WEST SUSSEX COUNTY COUNCIL CONSULTATION

TO:	Arun District Council FAO: Maria Tomalova
FROM:	WSCC - Highways Authority
DATE:	11 November 2020
LOCATION:	Old Barn Free House 42 Felpham Road Bognor Regis PO22 7DF
SUBJECT:	FP/209/20/PL Change of use of the ground floor public house (Sui Generis Use) to create 2 No. 2 bed dwellings (C3 Use Class), subdivision of the first floor 1 No. 5 bed flat to create 1 No. 2 bed flat & 1 no. 1 bed flat. This site is in CIL Zone 4 (Zero Rated) as flats.
DATE OF SITE VISIT:	n/a
RECOMMENDATION:	Advice
S106 CONTRIBUTION TOTAL:	n/a

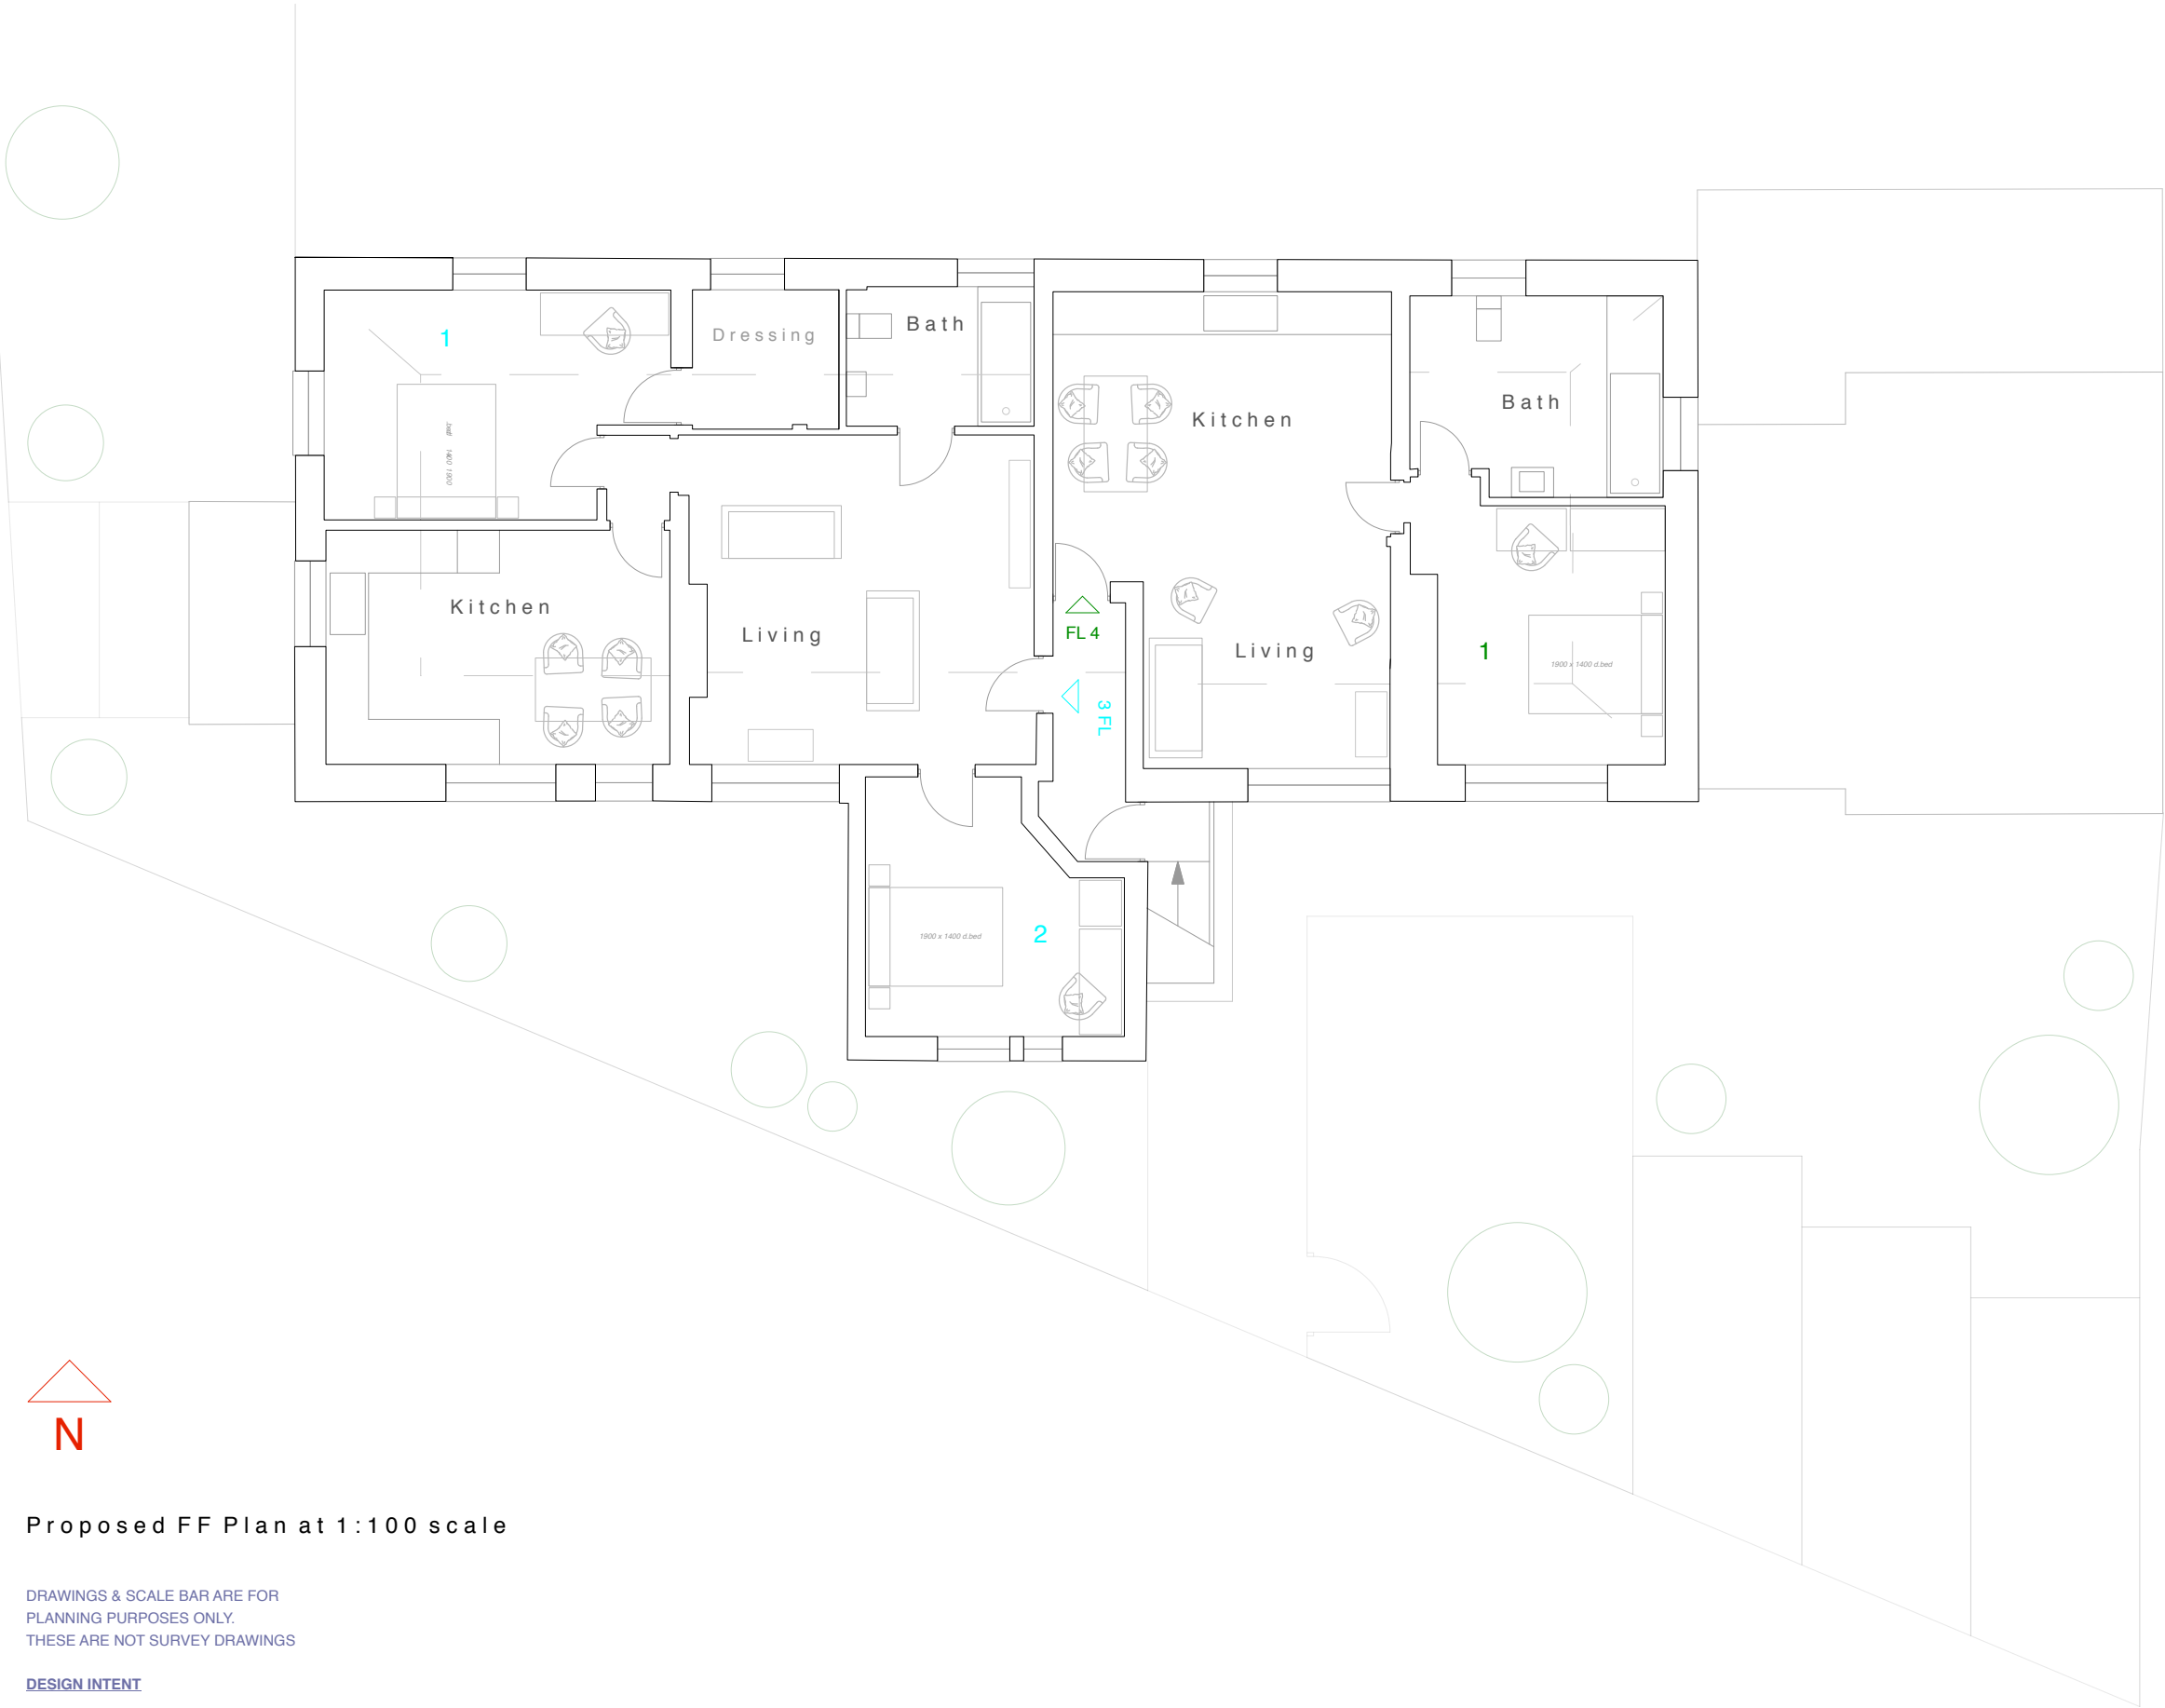
The plans indicate that eight parking spaces will be provided for the proposed dwellings, on an unallocated basis. The WSCC Parking Demand calculator expects that a minimum of 8 unallocated parking spaces would be required for a development of this size and location, therefore no concerns regarding parking would be raised. The proposed parking spaces meet minimum specification of 2.4 x 4.8m as set out in Manual for Streets.

The site is sustainably located within walking distance of a variety of local shops, services and amenities. Cycling is a viable option within the vicinity. It appears that cycle storage is proposed for the two ground floor flats within the private gardens. Storage should also be provided for the first floor flats and could be accommodated within the communal garden. Details of secure and covered cycle storage for each flat can be secured via condition.

No part of the development shall be first occupied until covered and secure cycle parking spaces have been provided in accordance with plans and details to be submitted to and approved by the Local Planning Authority.

Proposed Site Plan at 1:500 scale

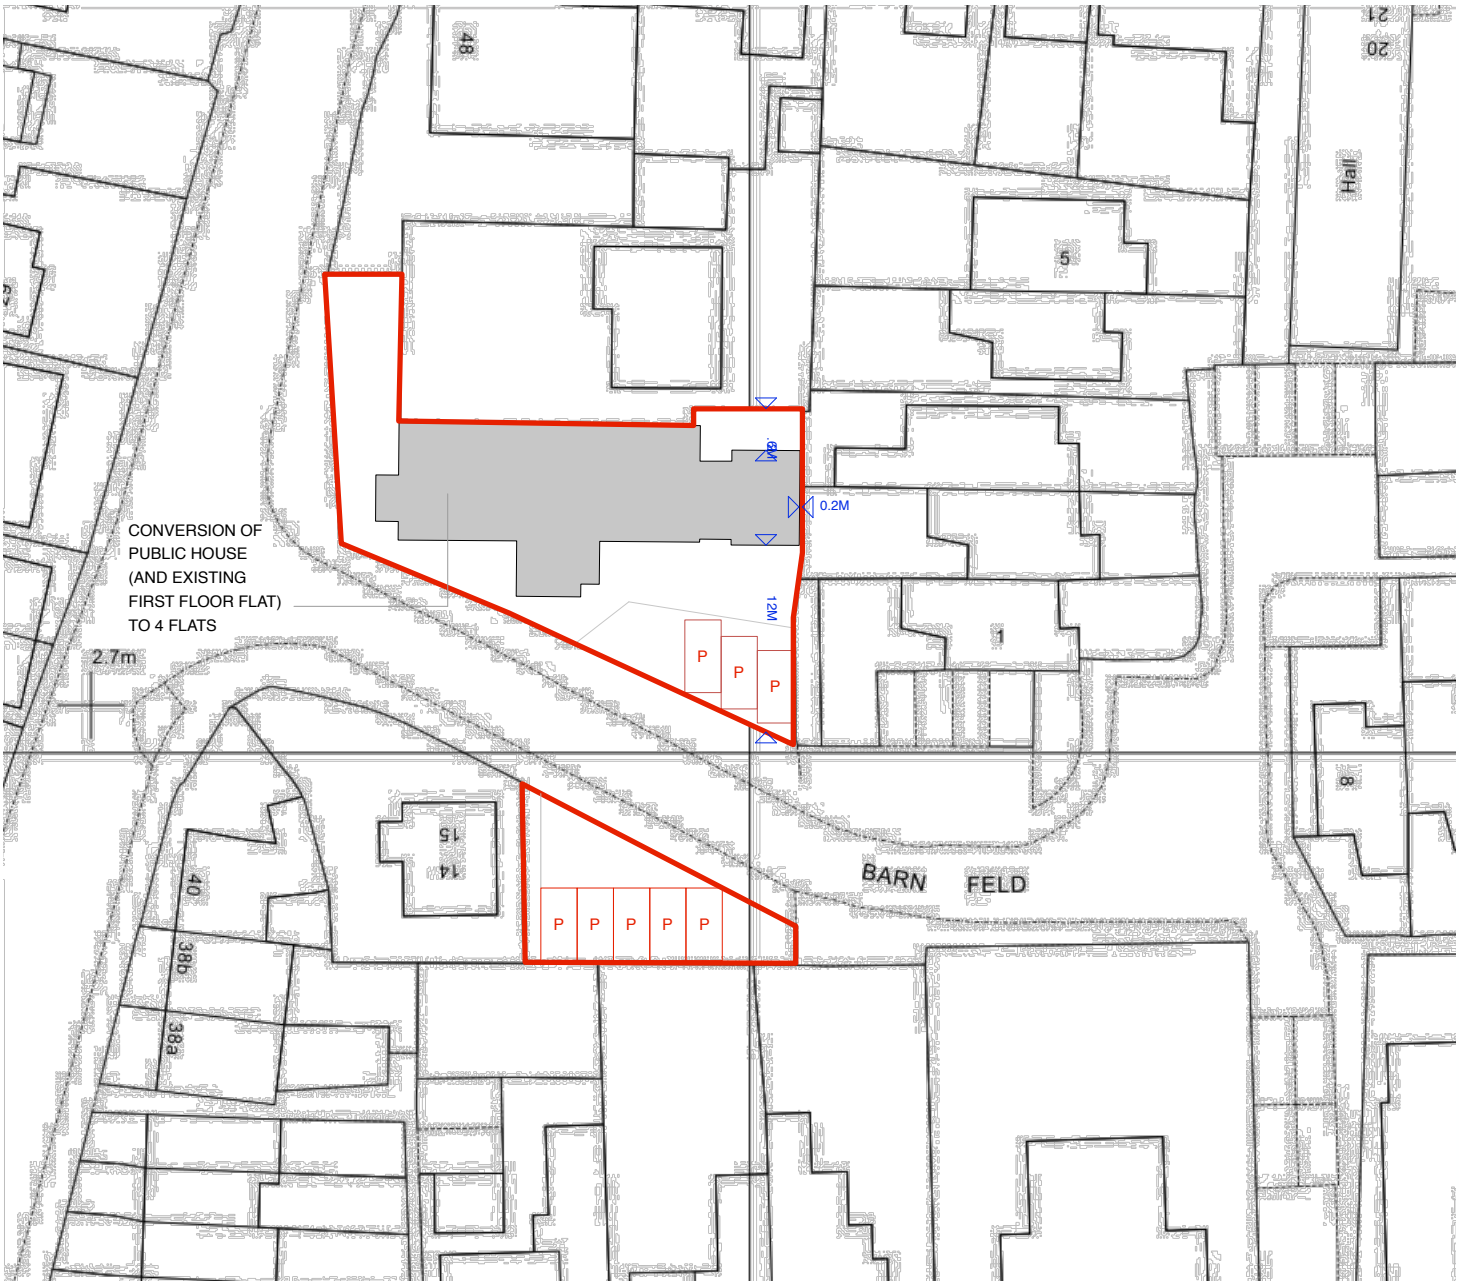
The application form indicates that no alterations to the proposed access arrangements are proposed. However, it appears that the proposed parking provision for the dwellings will utilise the existing parking area on the southern side of Barnfeld, and the existing parking area on the northern side of Barnfeld will be relocated to the east of its current position. This would require the existing vehicular crossover to the south to be widened for the entire width of the proposed parking bays, and would require the creation of a VCO to the northern side of the road. Whilst details of access can be secured via condition, the applicant may wish to resolve this matter prior to determination. The applicant should be aware that the proposed VCO's must be constructed to a specification agreed with the Area Engineer and works would be subject to a licence.

No part of the development shall be first occupied until such time as the vehicular access has been constructed in accordance with plans and details to be submitted to and approved in writing by the Local Planning Authority.

No part of the development shall be first occupied until the car parking has been constructed in accordance with the approved site plan. These spaces shall thereafter be retained at all times for their designated purpose.
